**Consultation Response from: KC Environmental Health (Pollution & Noise Control)**

**2025/91185 - Building at Back Chapel Lane, Moldgreen, Huddersfield, HD5 9BG**

**Demolition of redundant engineering building and erection of student accommodation block**

**Responding Date:  
09 July 2025**

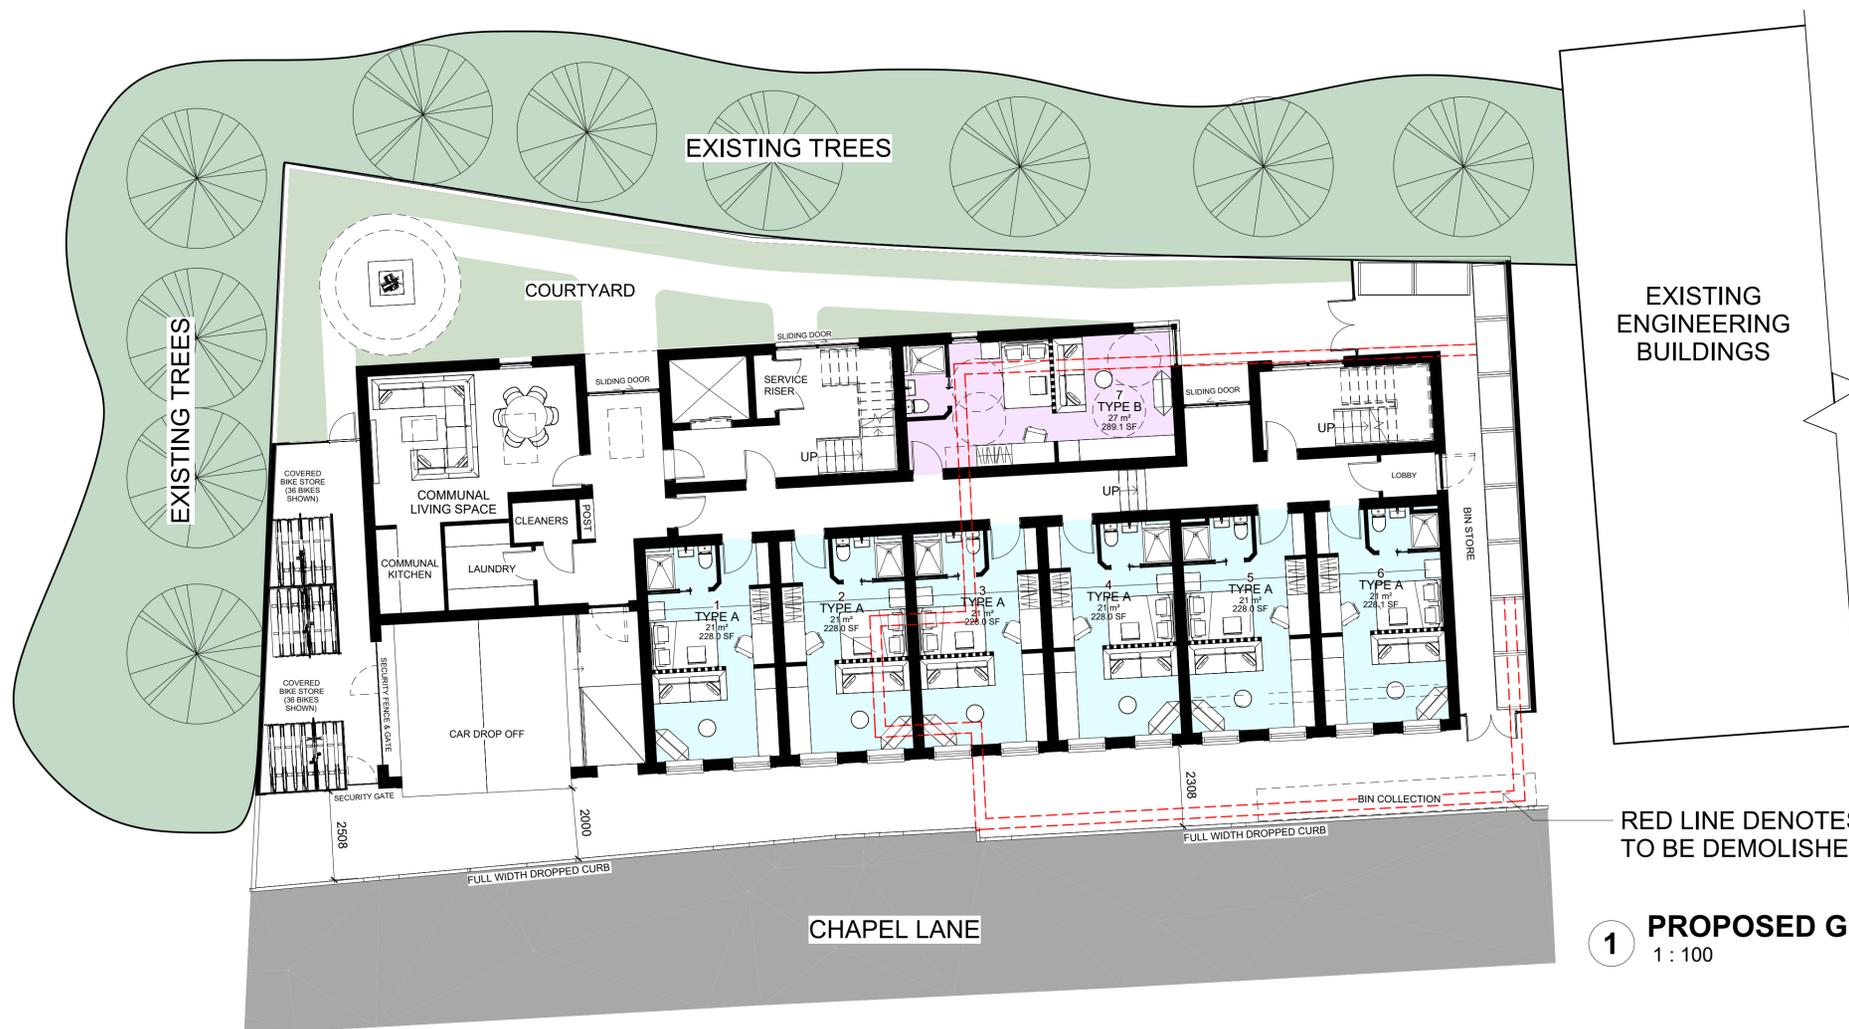
There is some shared amenity space to the rear as shown in the drawing no. (100)05 from Acumen dated Feb 2025 which will benefit from screening from the proposed building.
